Recommendation Report for Planning Permission for Works or Extension to a Dwelling**REF NO:** BE/159/12/**LOCATION:** 24 Ashurst Close
North Bersted**PROPOSAL:** Two storey side extension**SITE AND SURROUNDINGS**

PROPOSED FIRST FLOOR

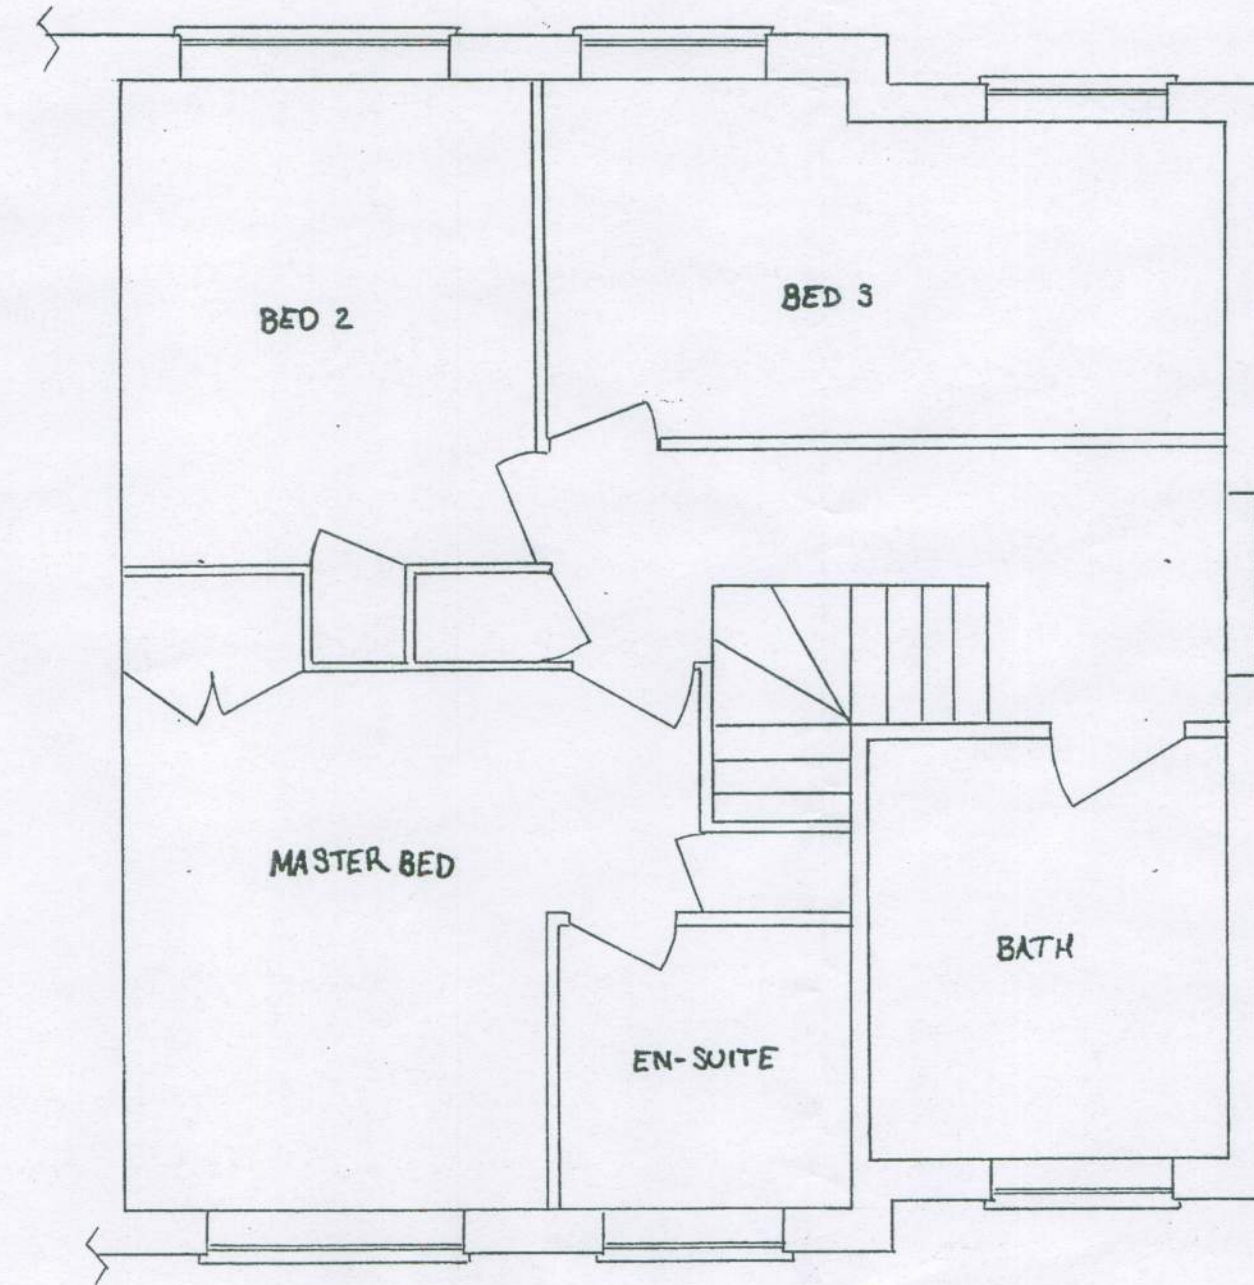
The Council would like the rear window to be obscure glazed and there is a 2m boundary space from the neighbouring fence.

The purpose of the proposed extension is to provide for adequate bedroom space for the applicant's growing sons and involves extending the third bedroom which is currently a tiny box room. This room already has a window in the rear elevation. Obscure glass is not normally fitted in bedroom windows and overlooking is not considered a problem with existing trees and shrubs giving adequate privacy. The existing fence is not on the boundary, a new fence will be erected in the correct position on completion of building works.

The application is to consider the extension and the replacement of fencing under 2m may be "permitted development". It is not appropriate to impose a condition that the rear bedroom window be obscure glazed as it is not considered that this would create any unacceptable overlooking that currently exists from the windows at first floor level.

PROPOSED NORTH EAST ELEVATION

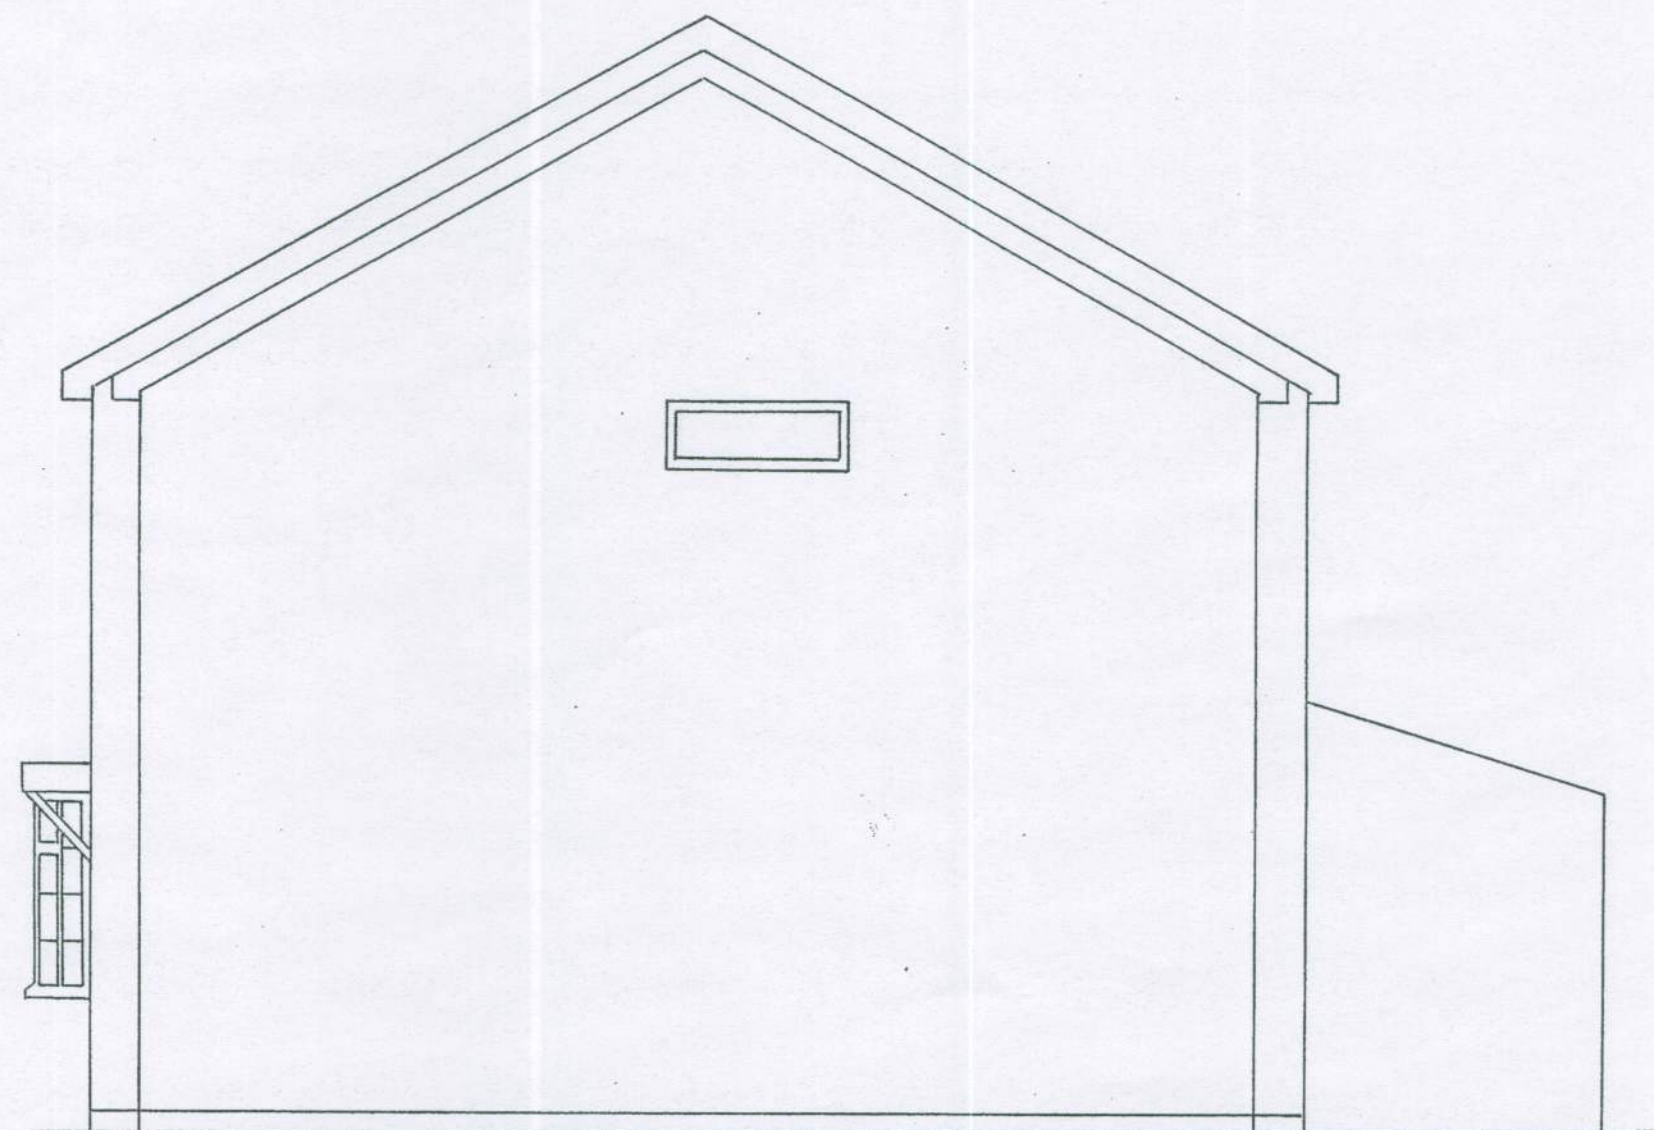
east elevation there is an existing landing window and the proposal will have a window serving the landing of the same dimensions. With adequate distance to No 387 it is not considered that the window would create any unacceptable overlooking than currently exists.
